Our Ref: R/270/19/HH

**Town & Country Planning Act 1990 (as amended)
Town & Country Planning (Development Management Procedure) (England) Order 2015
Application for Planning Permission for Works or Extension to a Dwelling**

Development Ground and first floor rear extensions - resubmission of R/197/18/HH

Location 1 Pigeonhouse Lane Rustington

PROPOSED BLOCK PLAN

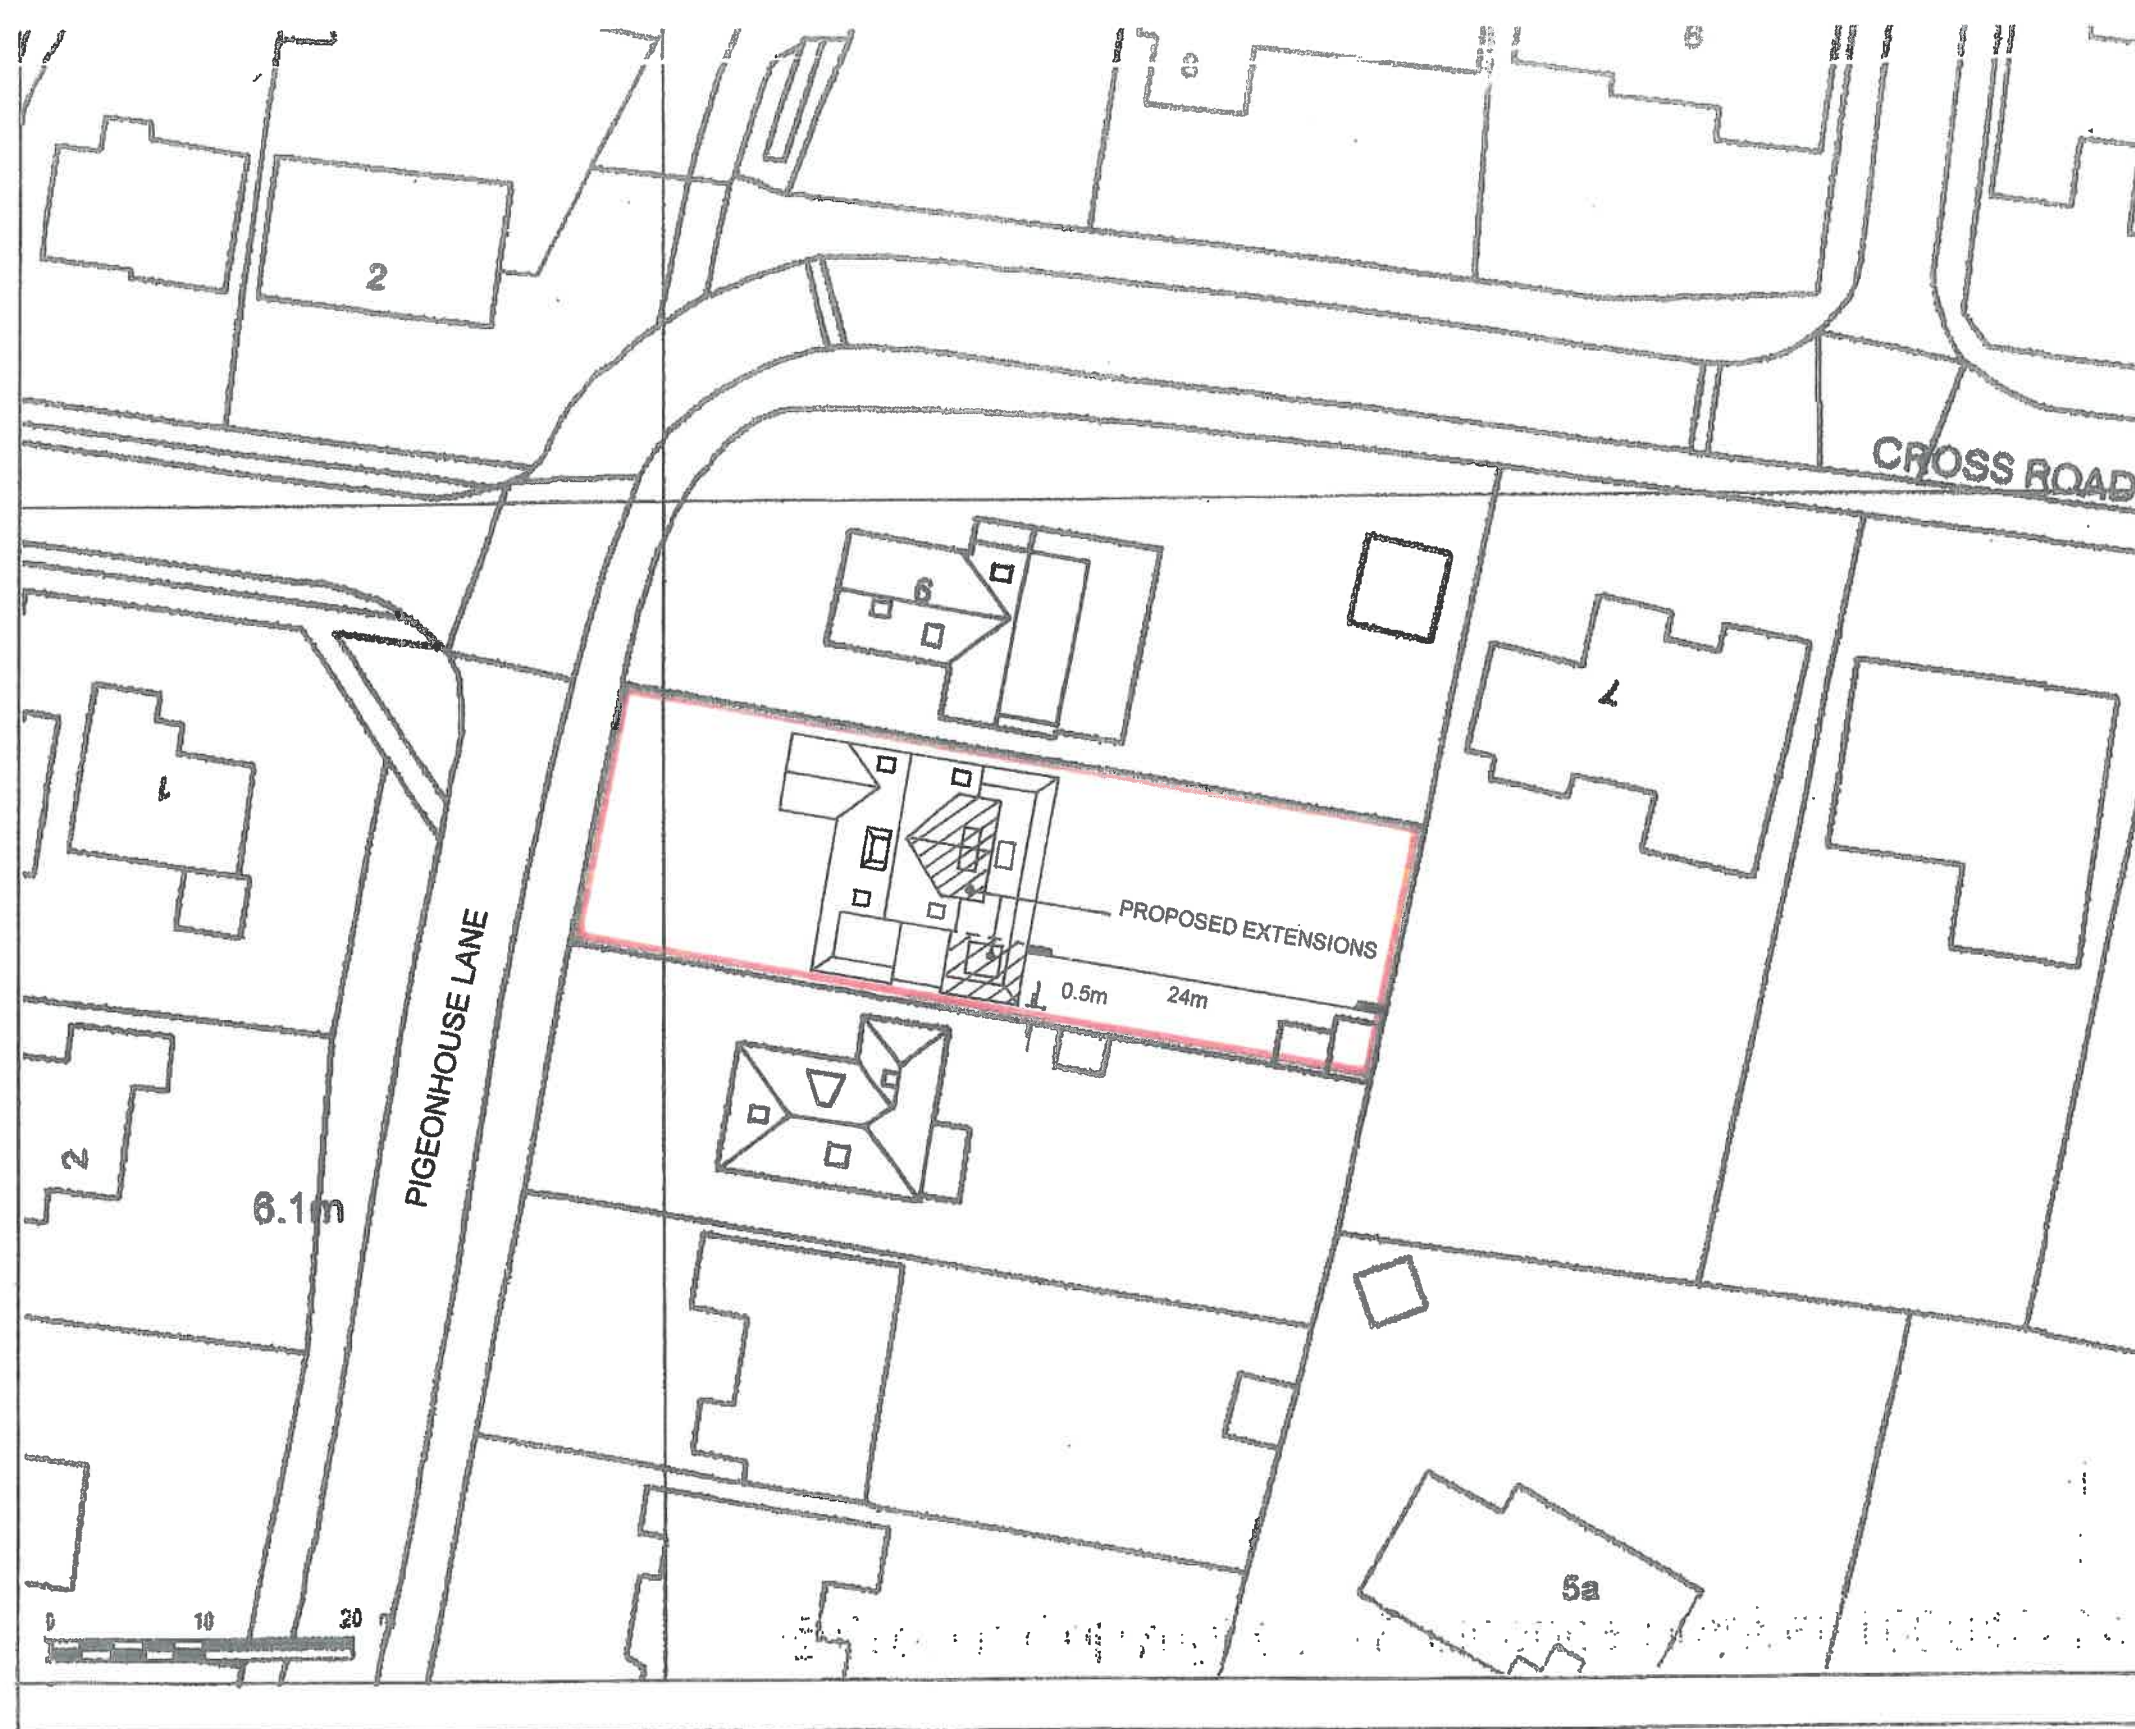
For clarity, please amend the Location and Block plan to show the road name of the site.
